Application number: 2024/93520	
What is the application for?:	Prior notification for single storey rear extension
Address of the site or building:	24, Smithy Close, Skelmanthorpe, Huddersfield, HD8 9DQ
Postcode:	HD8 9DQ

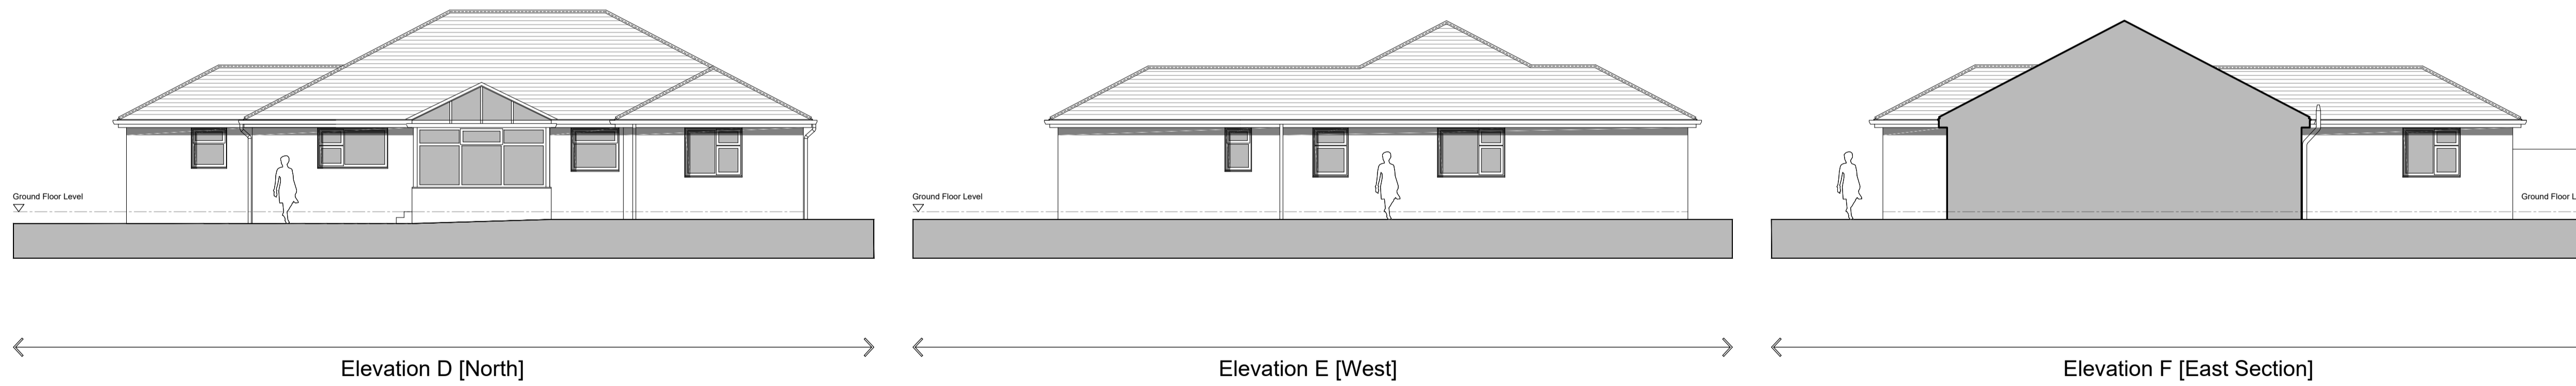
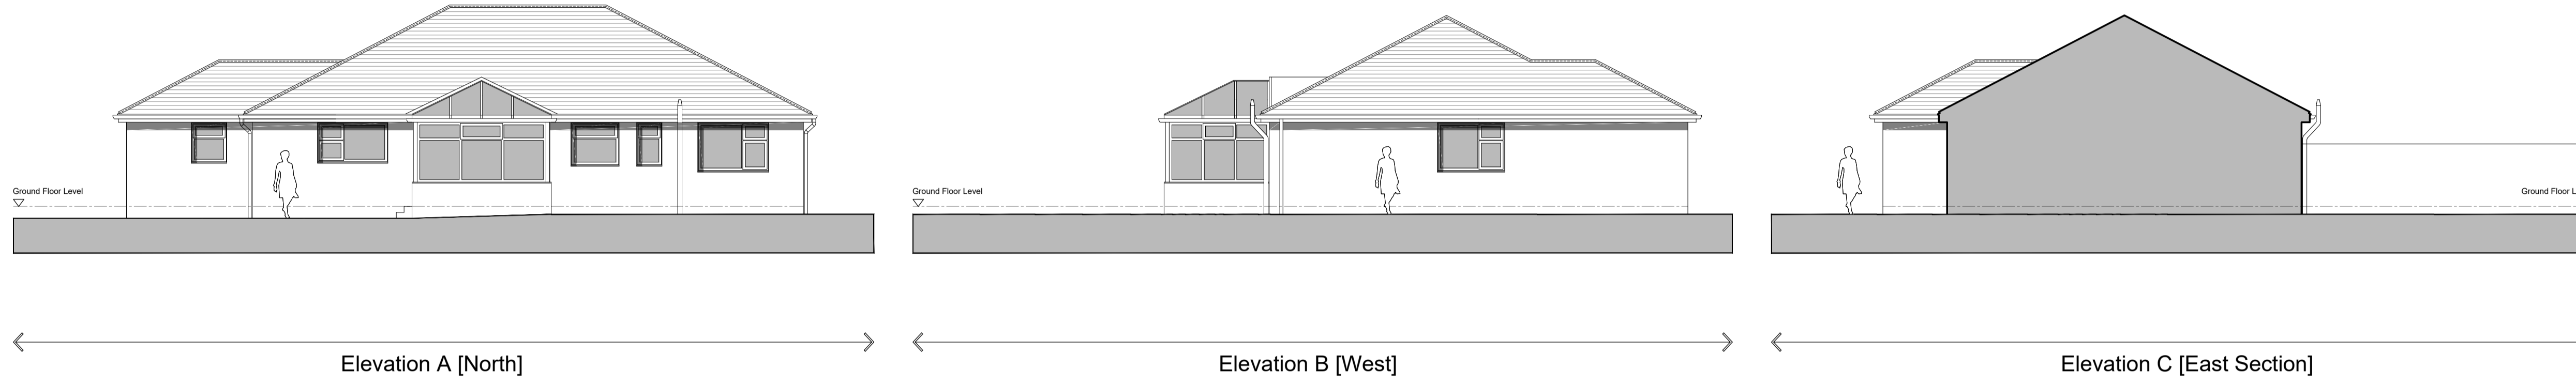
Type of comment: An objection	
Do you wish your comments to be published on the website anonymously?	Yes
<p>Our representations for this proposal are as follows: Considerable loss of amenity due to the height and scale of the extension. Even though there are no plans of the elevation included in the proposal of what type of gable is proposed, or indeed, if and where any windows and doors are to be included and situated.</p> <p>The proposal will impact on the amenity all of the neighbouring bungalows by causing an overview of their rear gardens amounting to a loss of use and enjoyment of these gardens.</p> <p>Due to the downward slope of the land to the rear of the property, there will also be a great loss of the amenity of privacy in the back bedrooms of the bungalows over the rear boundary. These bedrooms will be directly overlooked from a much higher level by the proposed extension. Also would consideration be made in this regard to the siting of any security cameras and any outdoor lighting be shielded from glare.</p>
